MONUMENT RIDGE EAST FILING #1
LOCATED IN THE NORTH ONE-HALF OF SECTION 2, T 11 S, R 67 W OF THE 6th P.M.
EL PASO COUNTY, COLORADO

V5_Final Plat Drawings.pdf Markup Summary

SEE SHEET 3

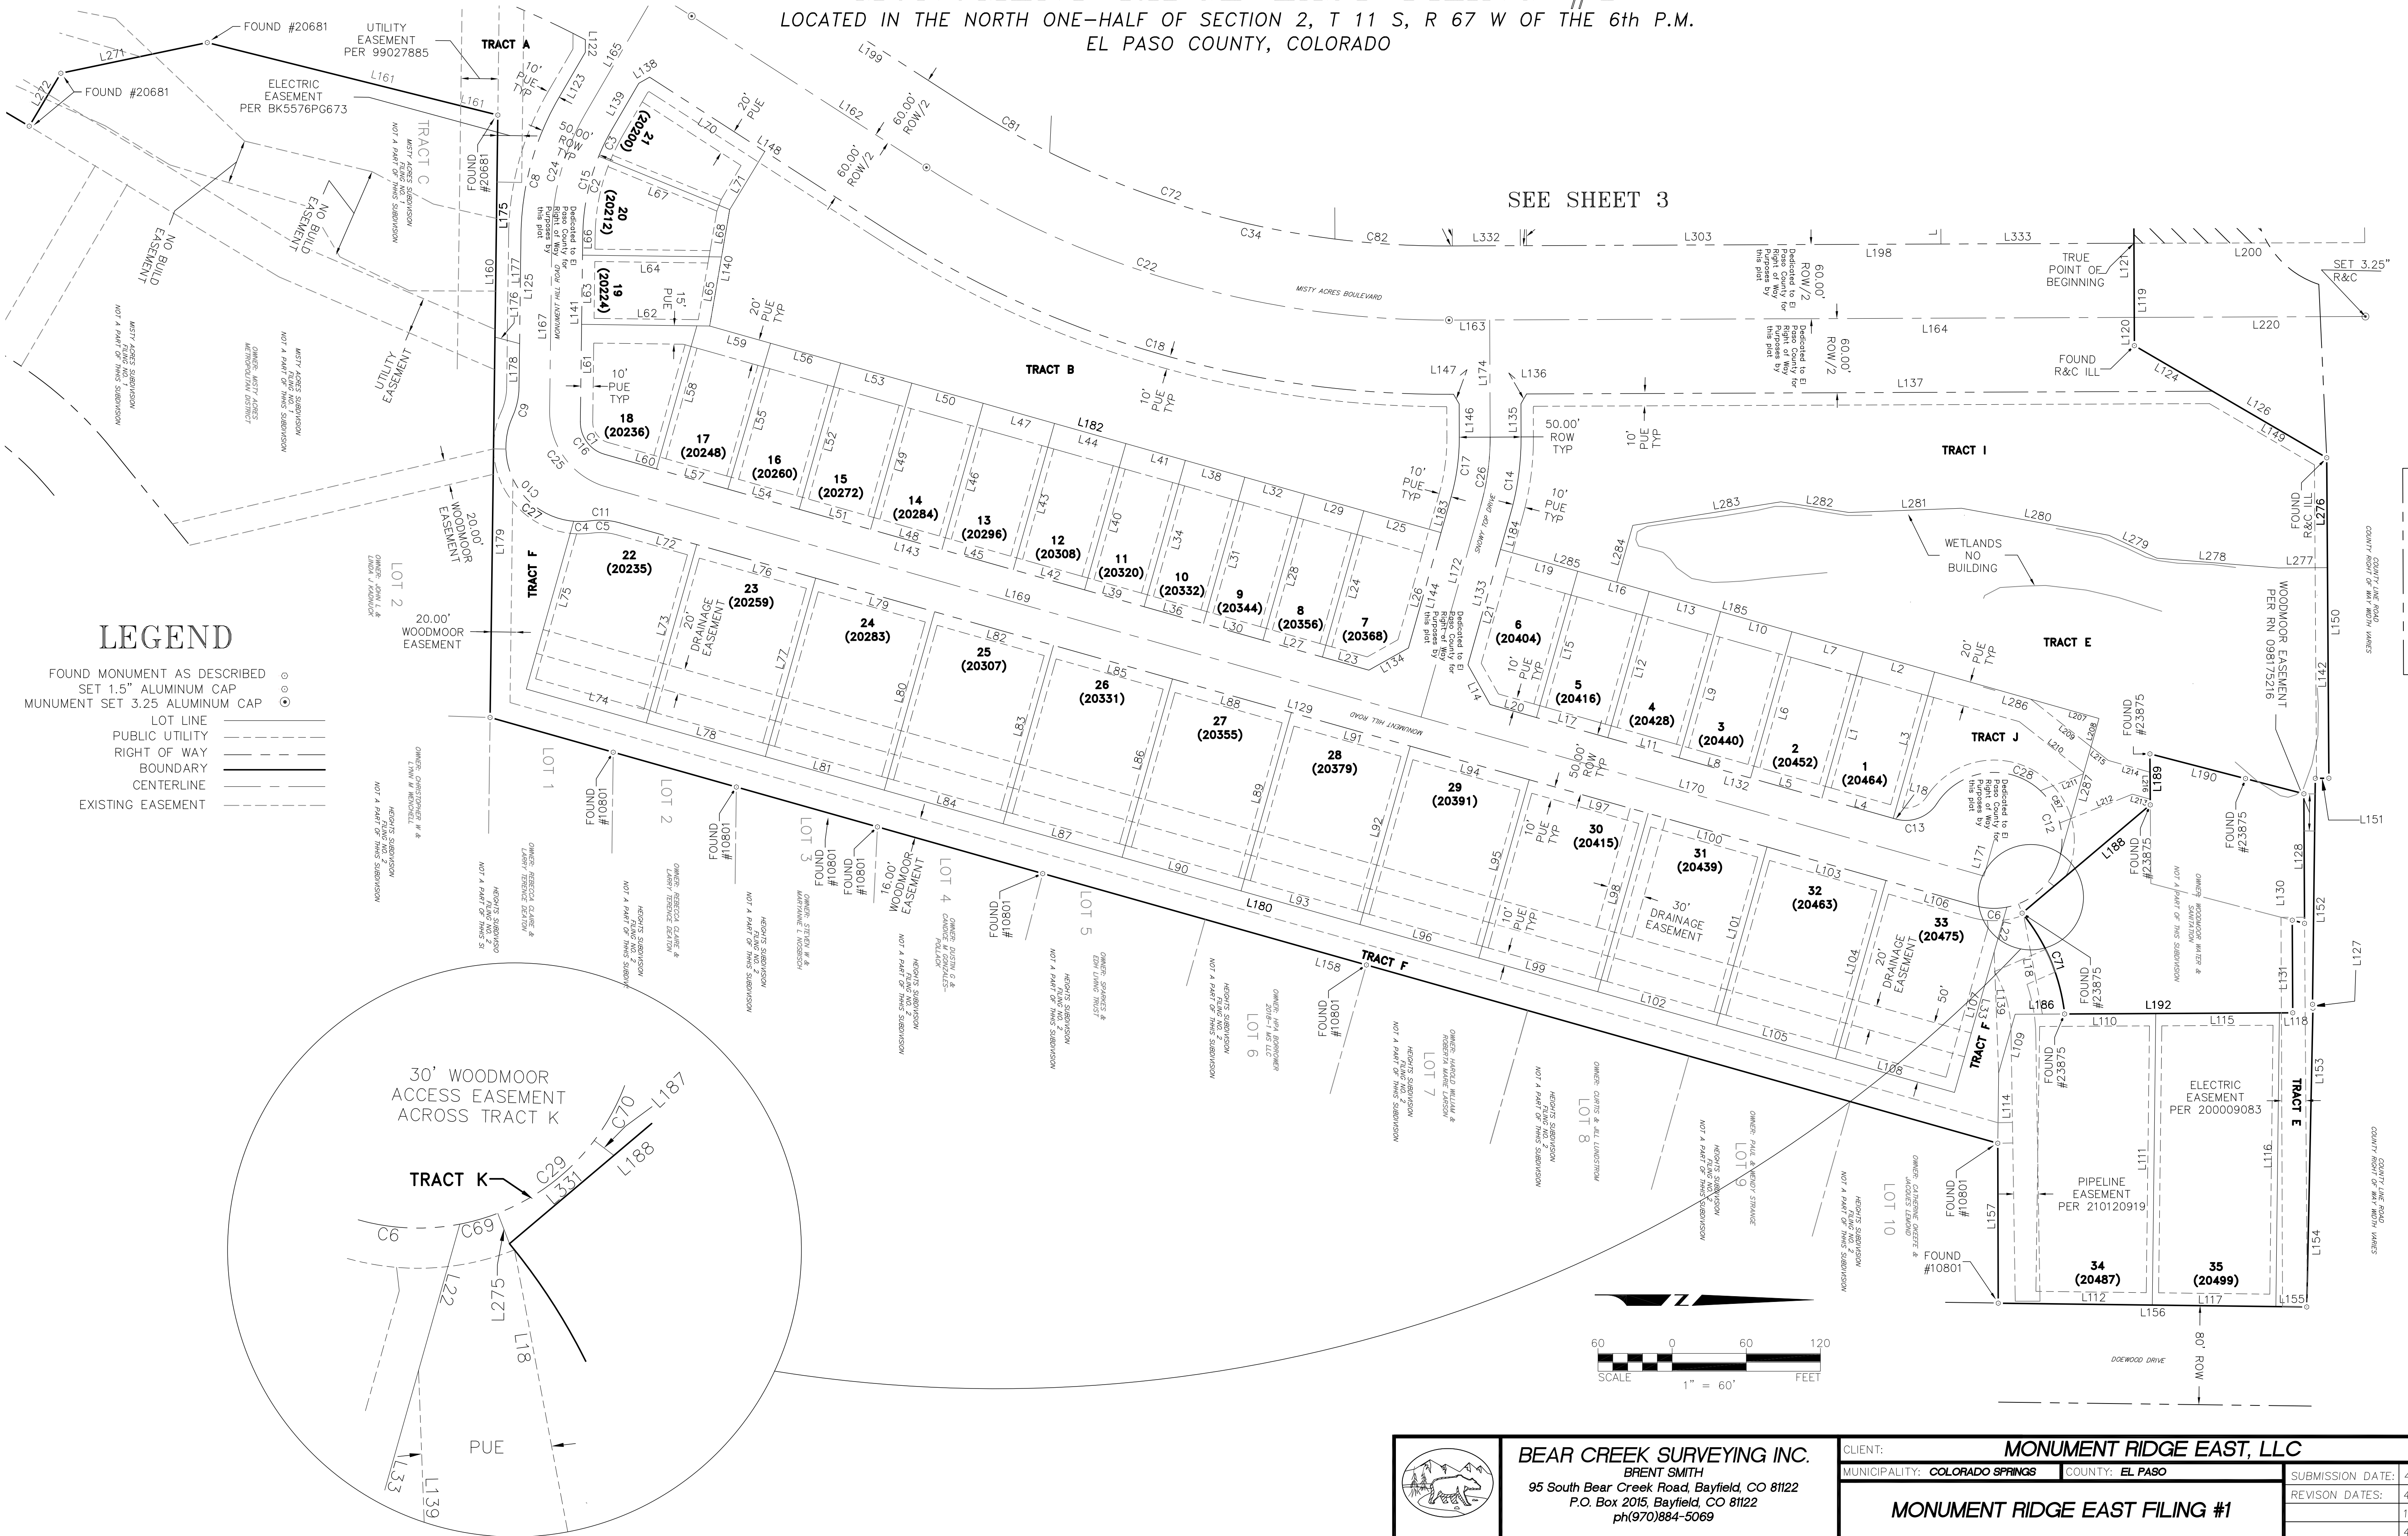
Provide easement for storm collector

Include wetlands line work

Line work makes it difficult to determine the extent of the wetlands

8.4.3.B.5.e states Lots Divided by Easements. Lots should not be divided by easements. Drainage easements which bisect a lot are only allowed where no reasonable alternative to the drainage solution exists.

Suggest moving easement based on this section of code.

Per drainage report, plat is supposed to be showing easement for downstream culverts crossing County Line Road and outlet protection. Please show easement and label.

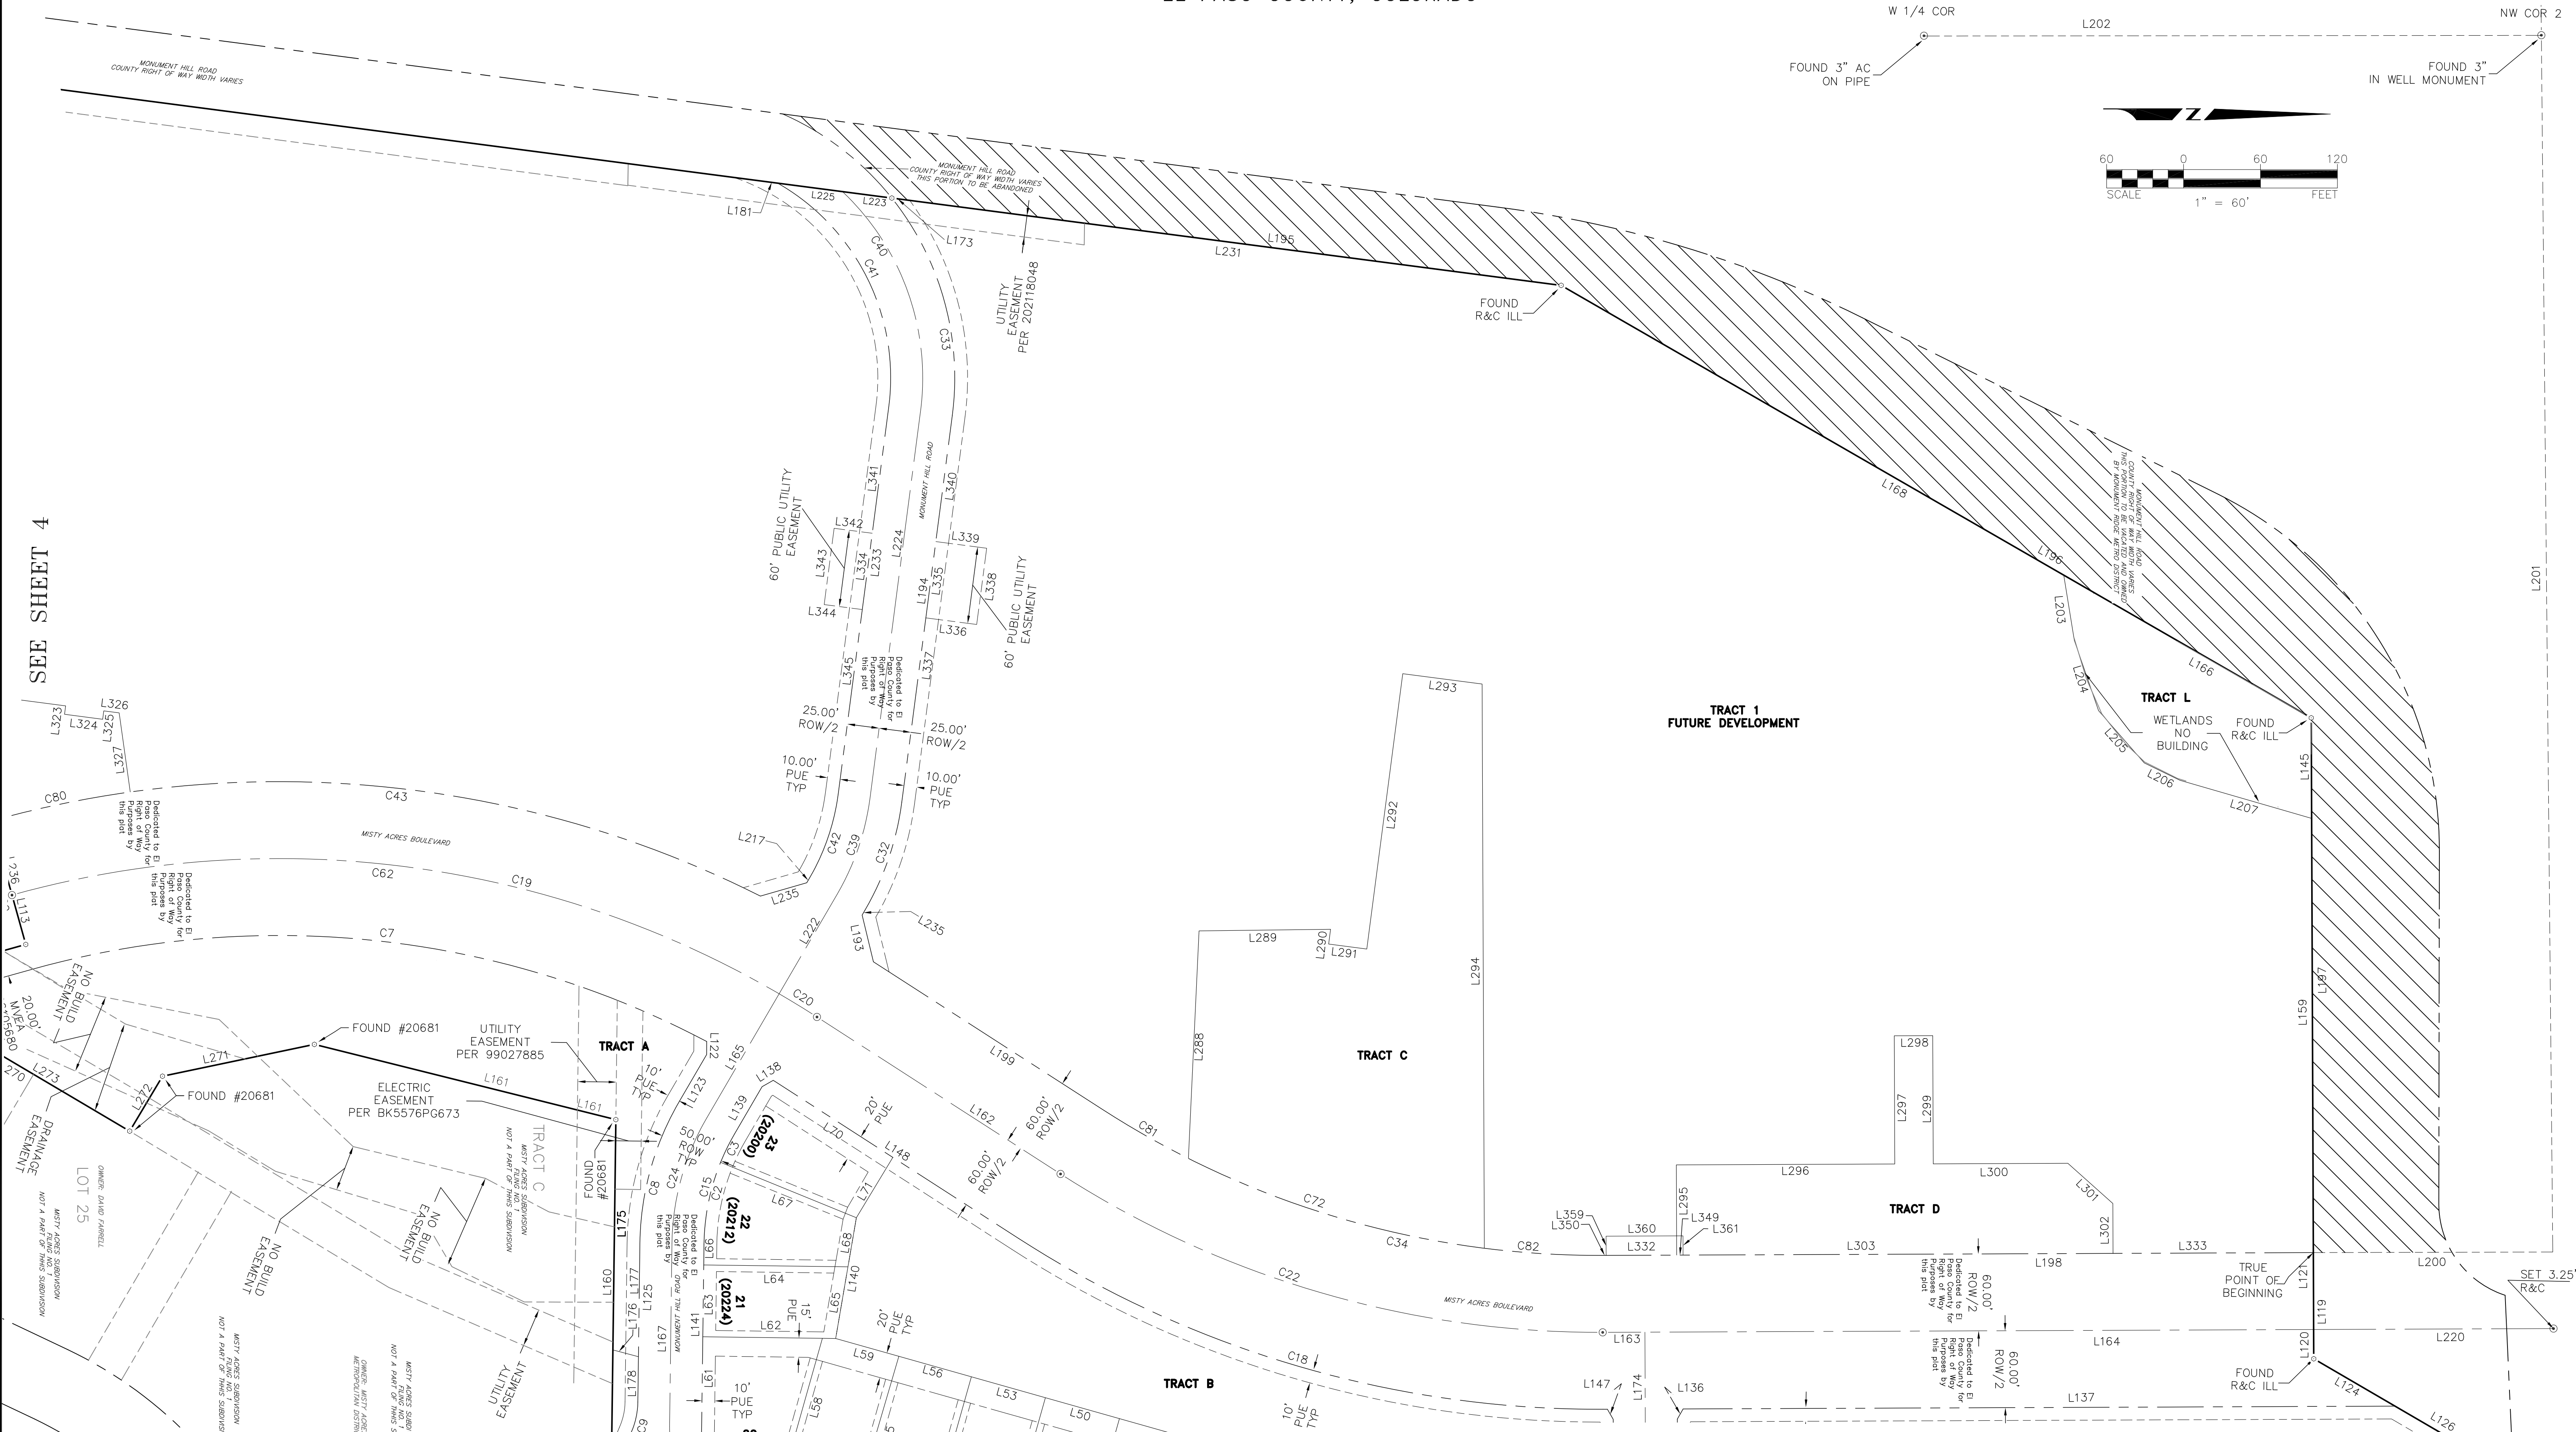
This part of Monument Hill Road is a local classification.
